Application No: FP/81/20/HH
Site Address: 26 Links Avenue Felpham PO22 7BX
Description of works: Installation of a dropped kerb/crossover.

Thank you for your internet representation made on 15th July 2020 which has been recorded as an objection with the comments as follows:

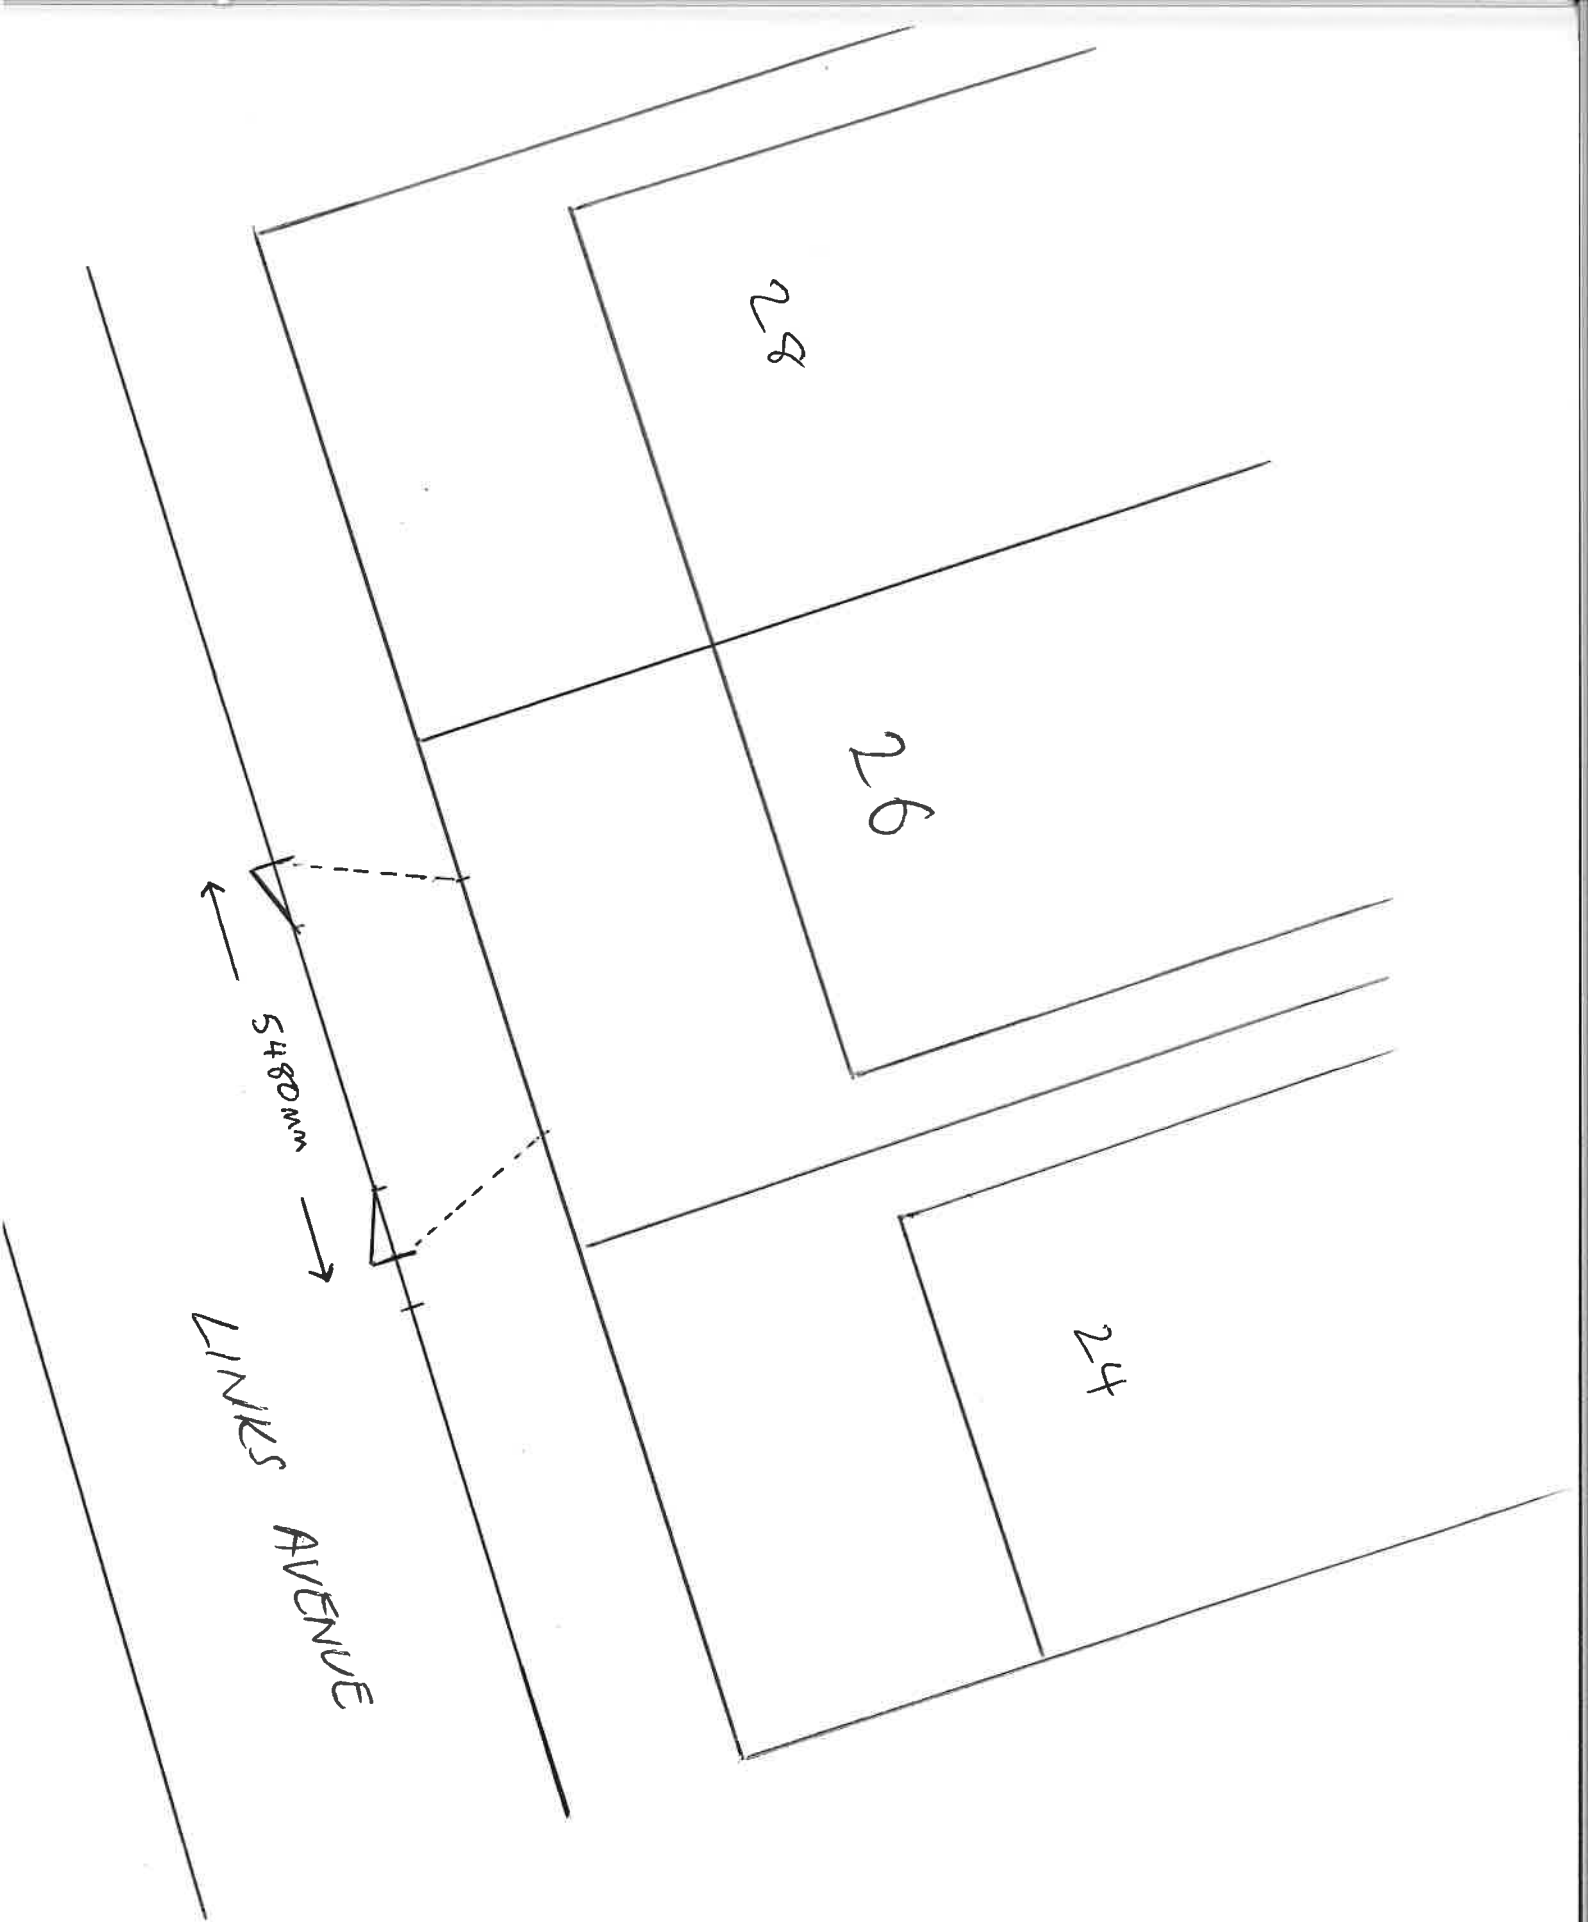
Objection. FPC agree with WSCC report that there is insufficient room to accommodate this.
